Martin Nugent
01254 828060
D3/11/0609

Drafted 4 October 2011

**Planning Application, Ribble Valley District
3/11/0609 15 Clitheroe Road, Sabden**

TITLE Proposed Site Plan	Drawn P.Lord Date 01.07.11 Scale 1:100@A3	Drawing No 79/2/02 B	Rev
-----------------------------	---	-------------------------	-----

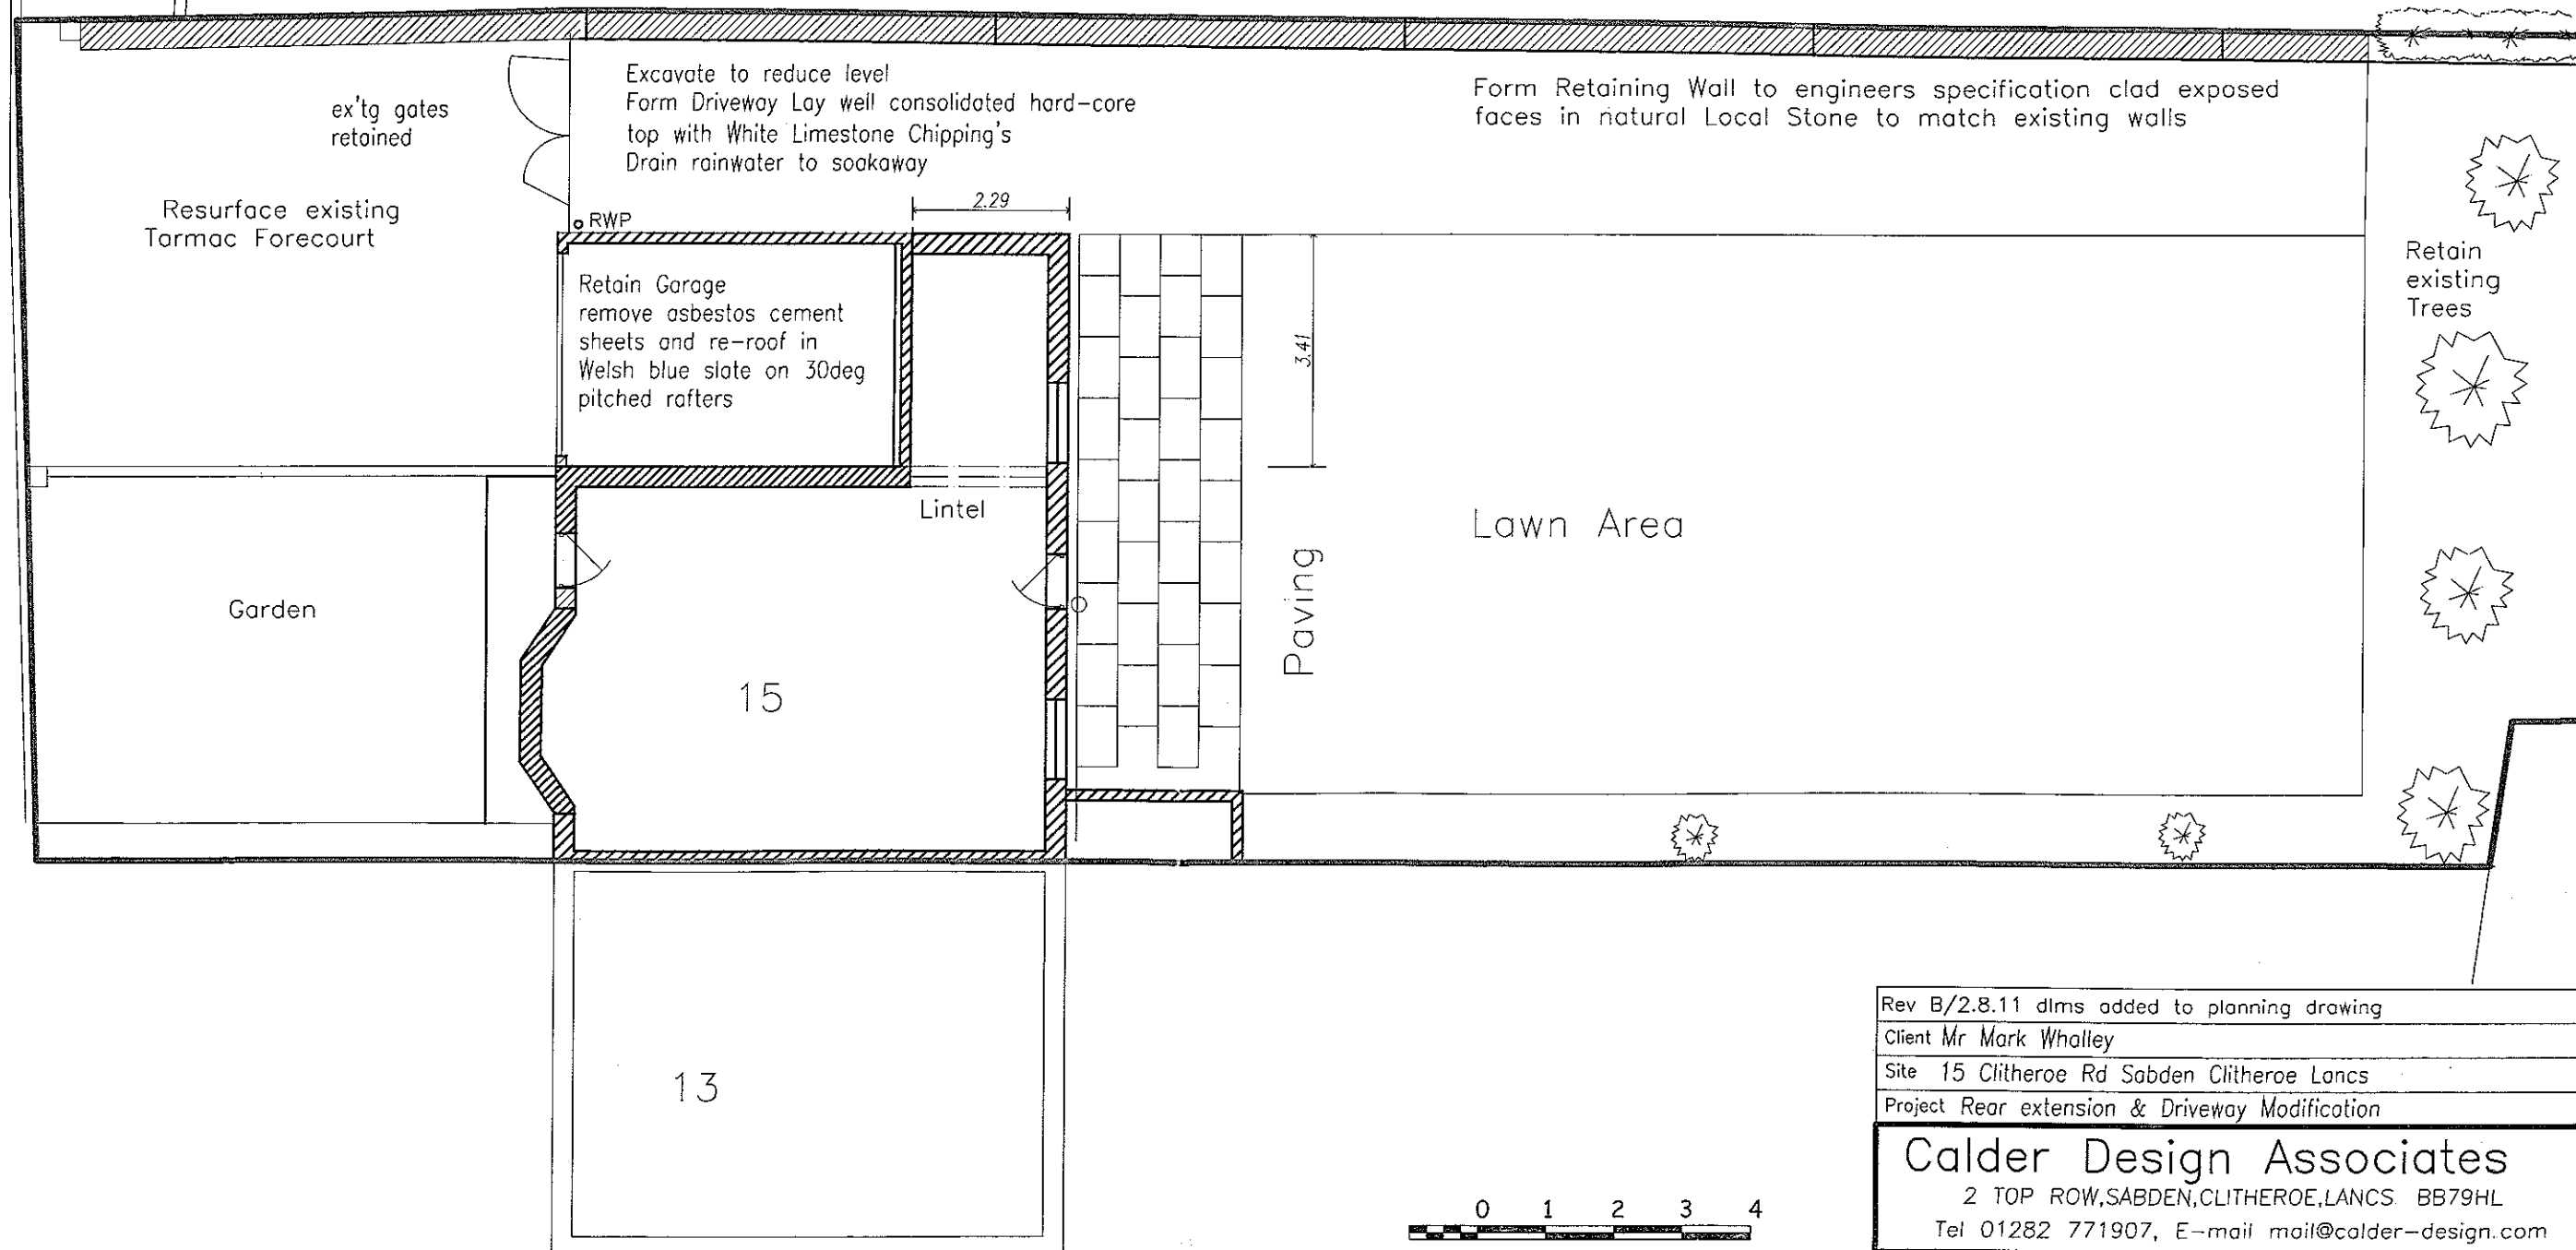
However, the excavation that is carried out on site must not impact on the utility of the adjacent access to the north of the site. For this reason, the construction of any retaining structure must be completed to an appropriate standard, submitted and approved by the Local Planning Authority in consultation with the Highway Authority.

Also, the height of the boundary wall to the north of the site must be constructed below a height of 1.0m for a minimum distance of 2.4m back from the edge of carriageway. This is to secure suitable visibility from the access to facilitate safe ingress and egress.
